RESPONSE TO SUBMISSIONS REPORT

SSD 34919690 – MOD 2
39-43 HASSALL ST PARRAMATTA

APRIL 2025

Level 7 - Landscape Planting

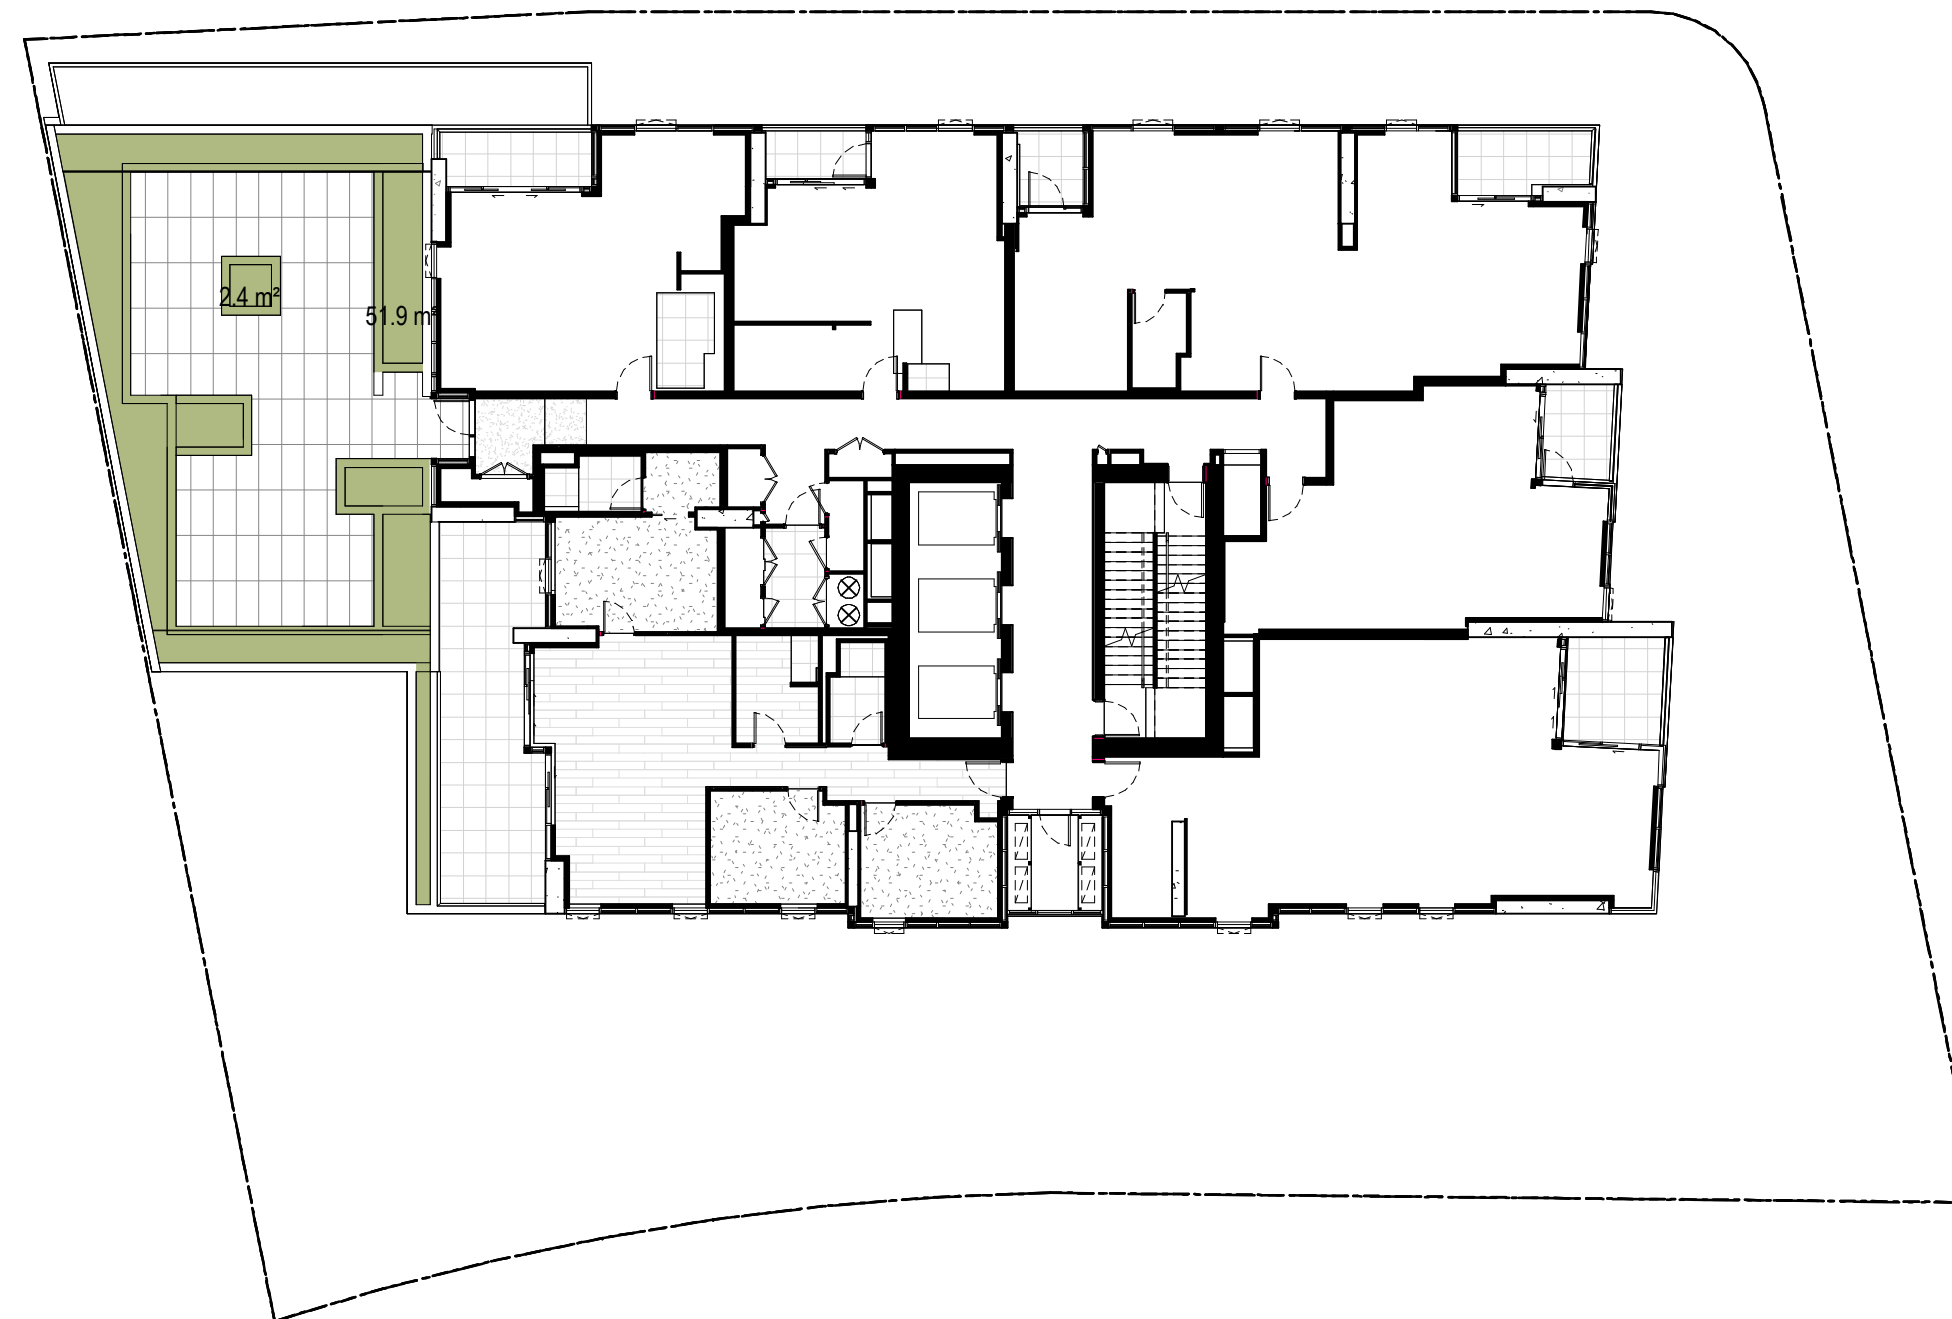
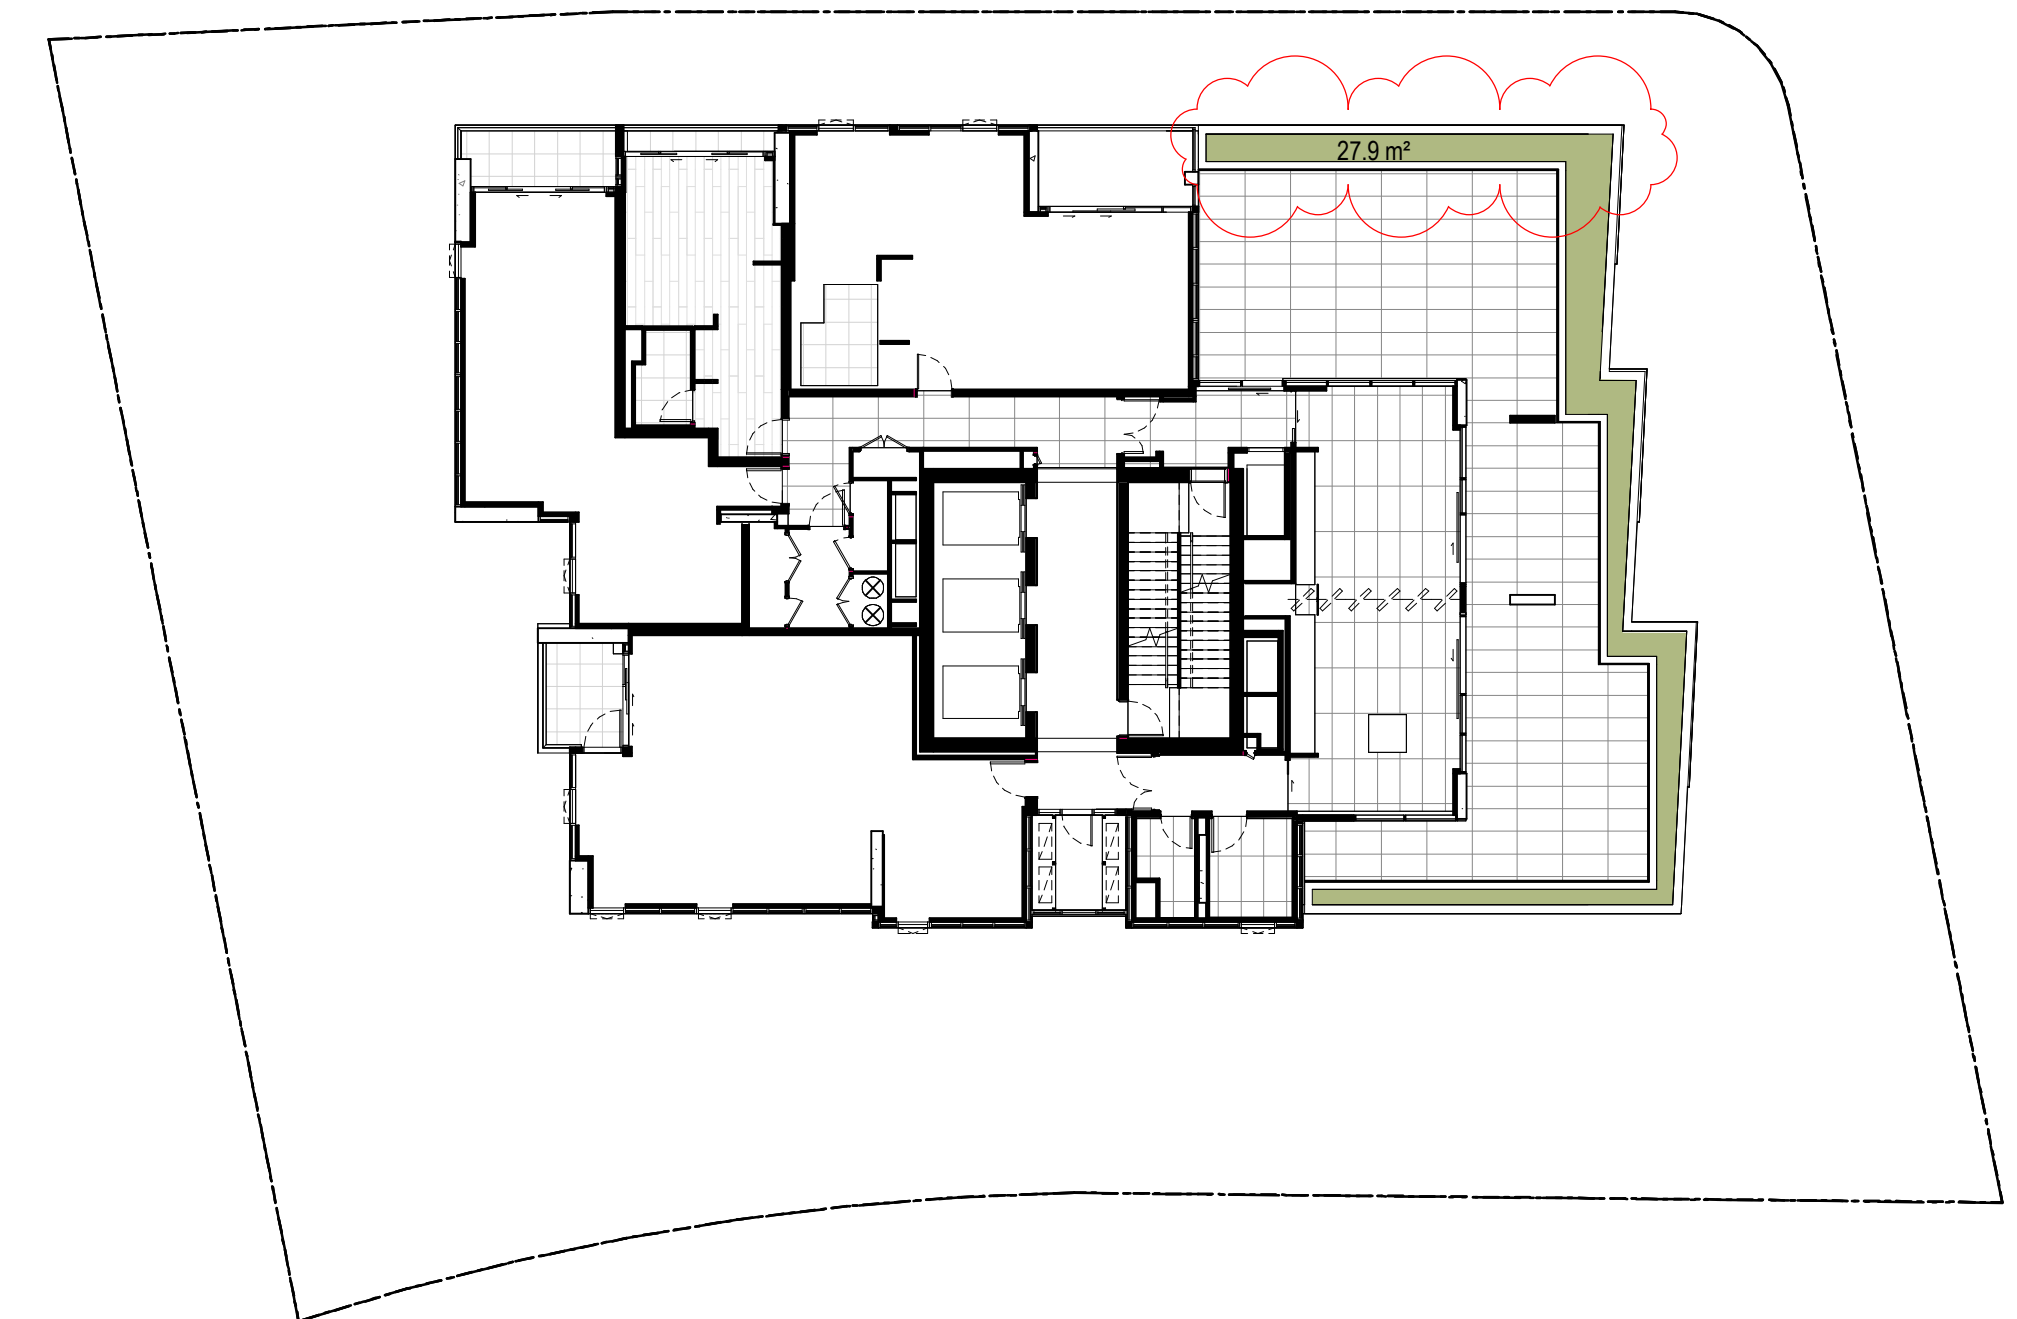
○ Section A of the landscape report does not show the basement structure only 1.2m from the boundary extent, below the proposed planting strip/riparian zone. ○ Planting on structure details are to be provided showing substrate depth, drainage, waterproofing for all planting on structures, including planting over the basement at ground level. ○ Soil volume, depth and soil areas on podium and over the basement must meet the following prescribed standards in the Apartment Design Guide (ADG) – Part 4, 4P <i>Planting on Structures – Tools for improving the design of residential apartment development</i> (NSW Department of Planning and Environment, 2015): ▪ Typical tree planting on structure detail to show overall 800-1200mm soil depth. ▪ Soil volume to be reflective of proposed tree species size	The landscape plan has been amended to show basement extent in Section A. Please see attached amended plans for details. Planting on structure details has been provided on Sheet 701 please see attached landscape plan for further details. Trees are only proposed within the ground floor. Planting on structure diagram has been provided on page 15. Soil Depth and volume are both compliant with the provisions of the ADG.
